**By COMMUNITY MEMBERS. OF LANE COVE COUNCIL's
BUSHLAND MANAGEMENT ADVISORY COMMITTEE (BMAC)
5 May 2066**

BMAC is a Lane Cove Council Advisory Committee with the objective of assisting Council in the formulation and implementation of bushland management strategies and initiatives. Within this objective BMAC provides this submission on SSD-82052708 (Lane Cove),

Figure 7 Visual representation of the proposed variation

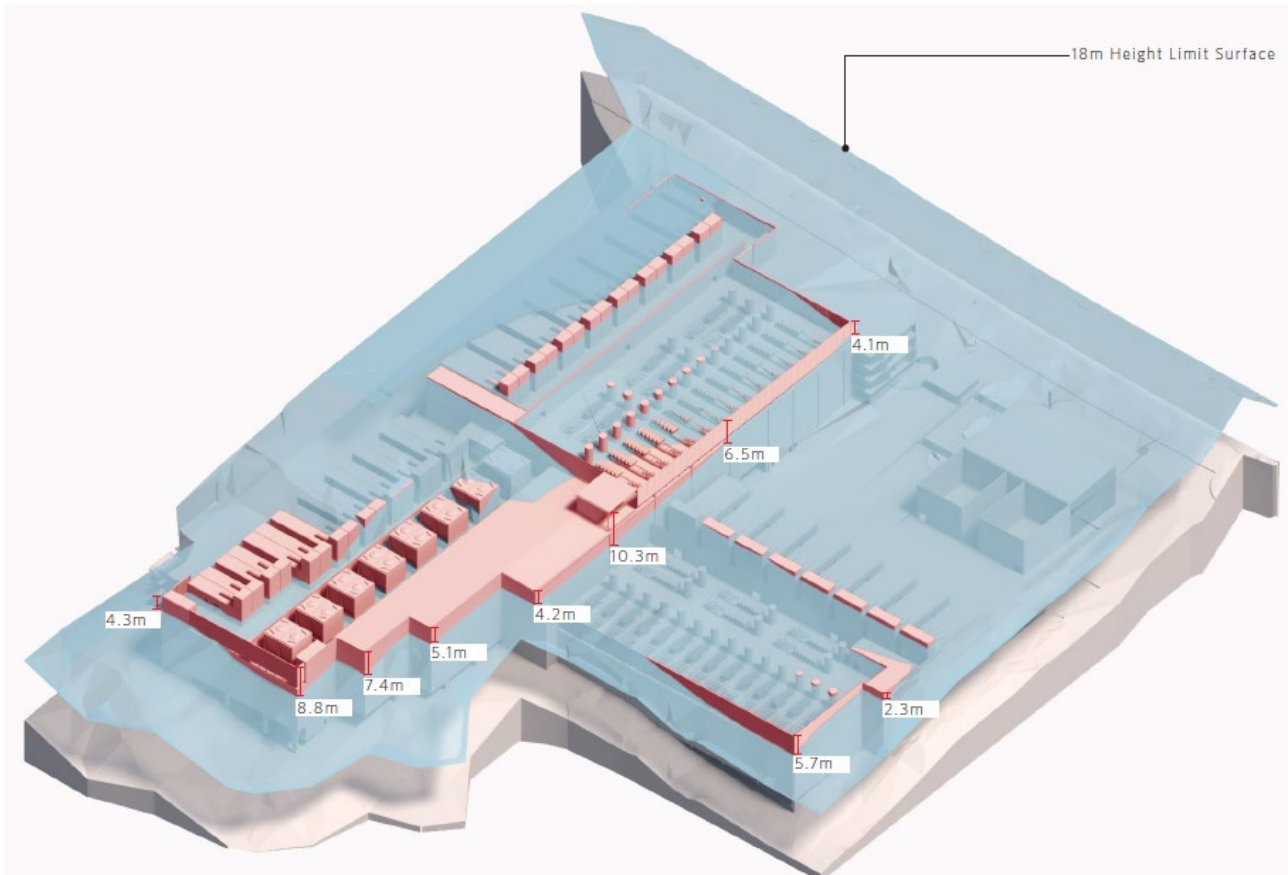
We formally object to the proposed 28.5-metre building height and current site configuration at 12 Mars Road. As stakeholders concerned with the Lane Cove Community Nursery and the adjacent bushland, we believe the proposal significantly impacts this critical community asset in the following ways:

The proposed height of 28.5 metres is 10.5 metres (60%) above the **18-metre limit** set by the *Lane Cove LEP 2009*. This excessive height creates an overwhelming visual bulk that is inconsistent with the "functional and attractive" design objectives of **Part E of the Lane Cove DCP**. The building will dominate the Community Nursery, fundamentally changing its character from a natural, open-space-adjacent facility to an enclosed industrial corridor.

1. Ensure all the information not yet provided regarding Noise has been provided by the applicant and when all the facts are available, be put out again for community consultation
2. Adhere to the 18-metre height limit and provide expanded setbacks that respect the Community Nursery's vital role in our local environment and protect the line of trees on the eastern boundary
3. Provide a more robust, independent assessment of the long-term hydrogeological and ecological impacts of such deep excavation in this sensitive location
4. Take into account the cumulative effect of impacts from multiple data centres within a confined local area.
5. Reduce the number of Data Centres in a confined area to alleviate the cumulative impacts on communities and the environment

Figure 8 Shadow Diagram – 21 June

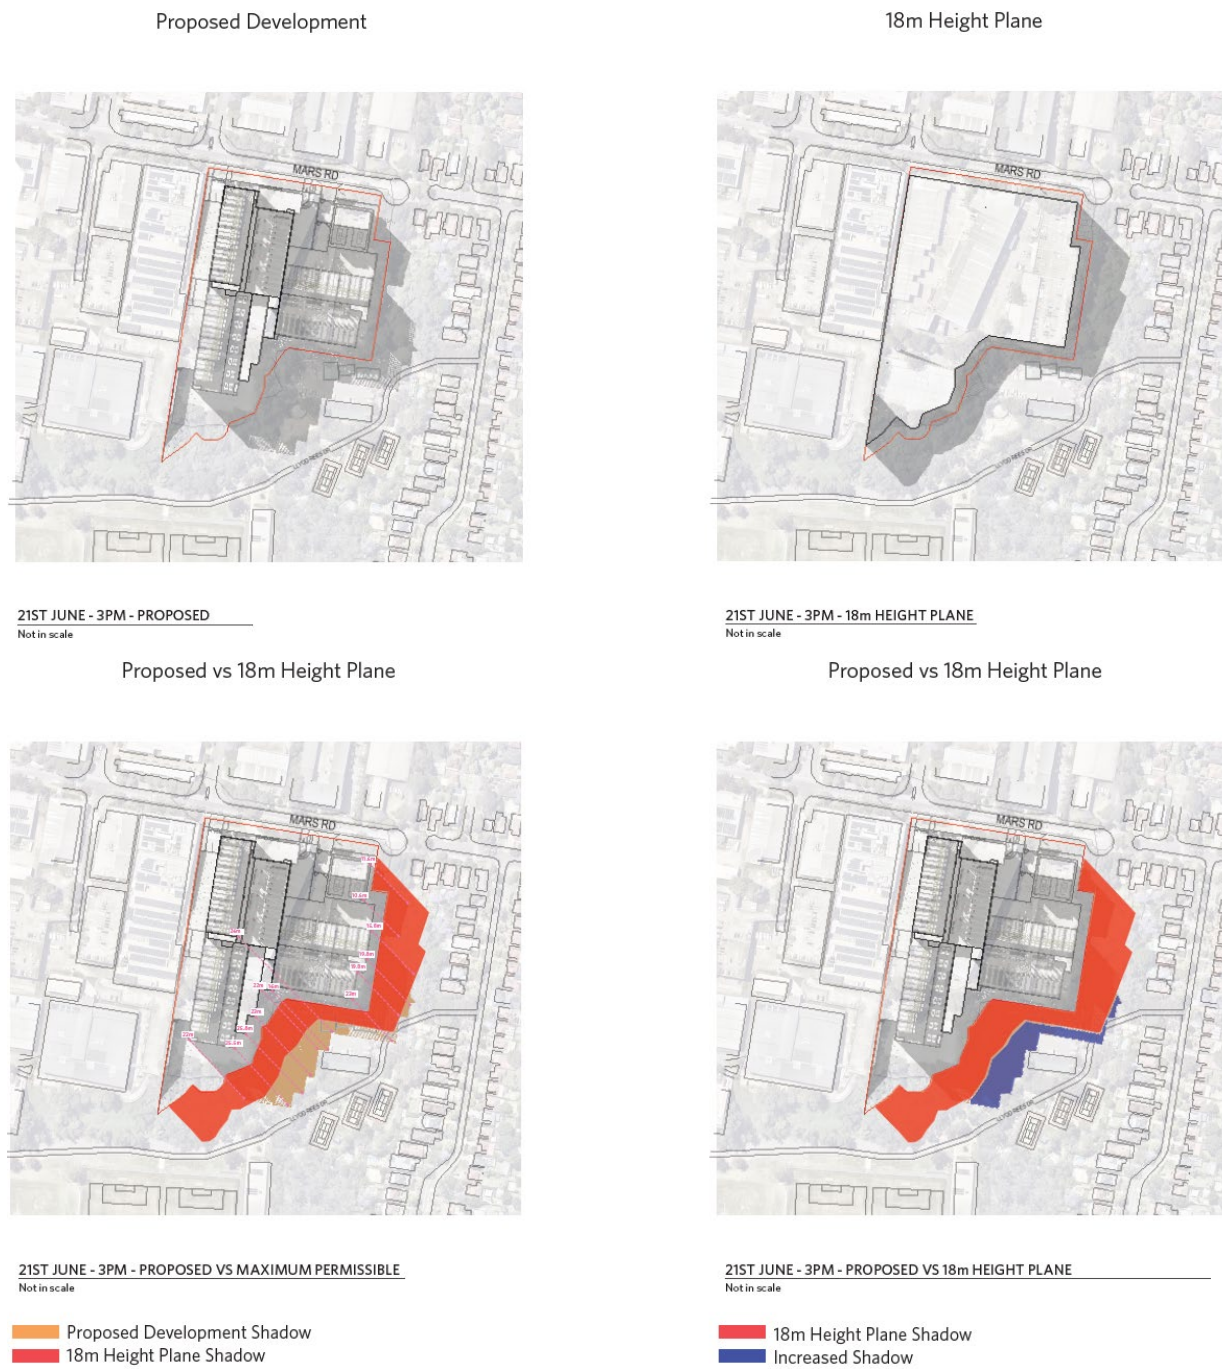
The Community Nursery relies on consistent solar access for the propagation of locally indigenous seedlings. A 28.5-metre structure on the southern/western boundary poses a severe risk of overshadowing, particularly during winter months. Any loss of sunlight will directly impede the Nursery's ability to provide tube stock for the Council's bushcare programs and 40% canopy target.

# 1.9 Existing Trees to be Removed

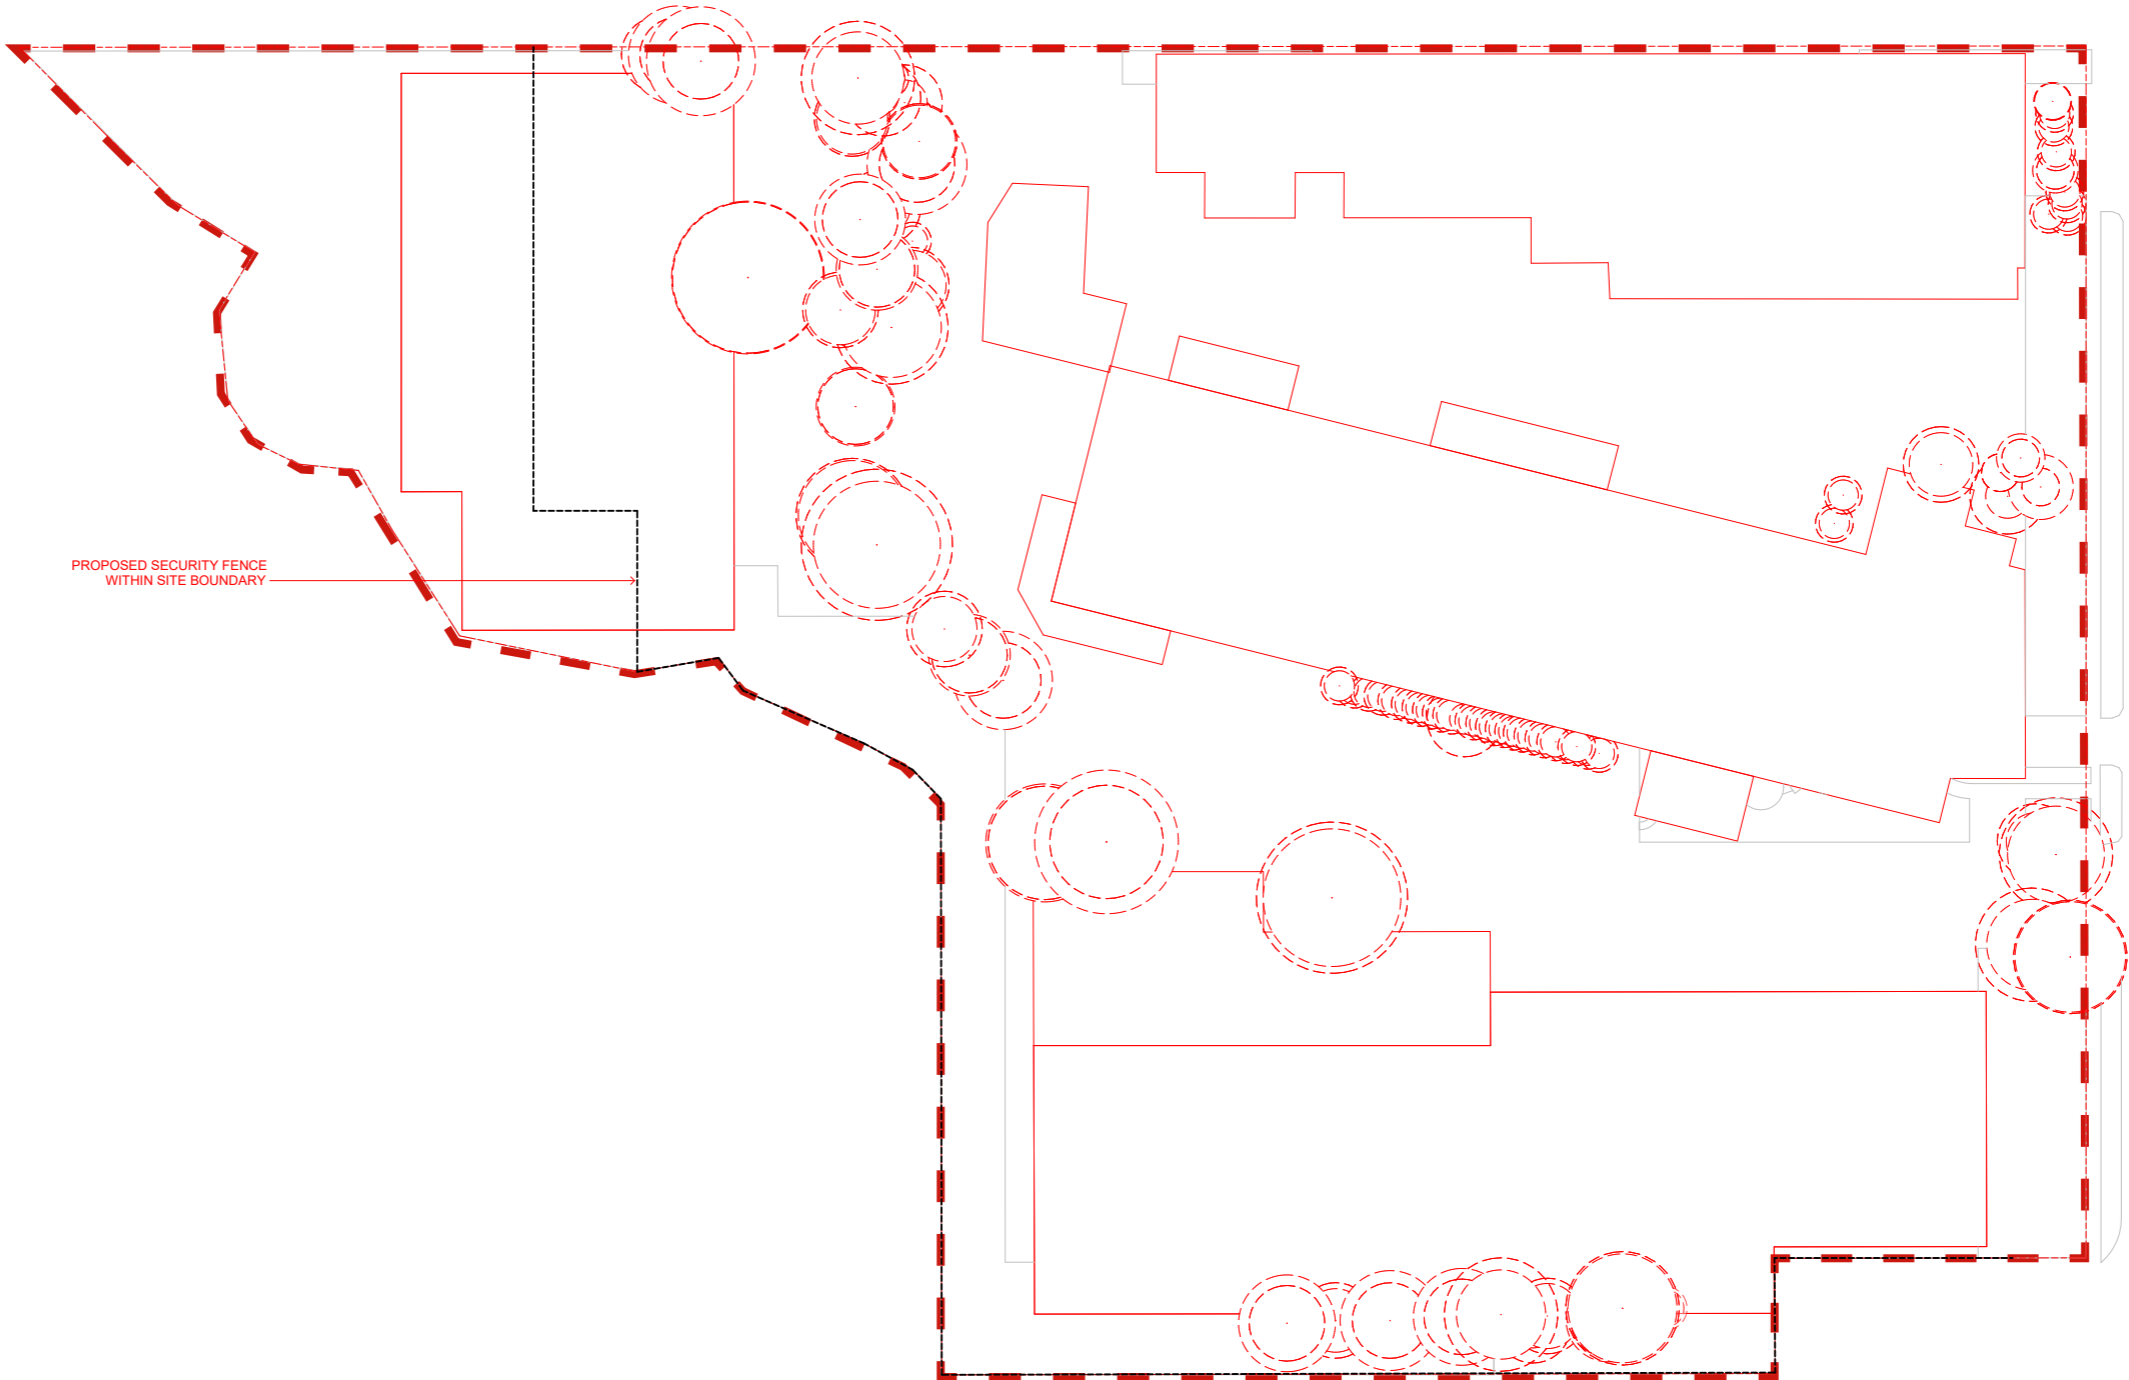
Loss of 90 Mature Trees

Losing so many trees in such an environmentally sensitive area is extremely concerning.

Biodiversity Offsets will not assist to obviate the loss in this environmentally sensitive area as they serve as a natural buffer between industrial development and Blackman Park and their loss will add a detrimental visual impact from the park.

Although the project ostensibly retains the trees on the eastern boundary adjacent to the Nursery, we believe the project will result in the loss of these trees due to impact on roots from deep excavation and construction impacts above ground, for example, lopping of the

trees to allow scaffolding and the strip on the eastern boundary becoming a construction zone.
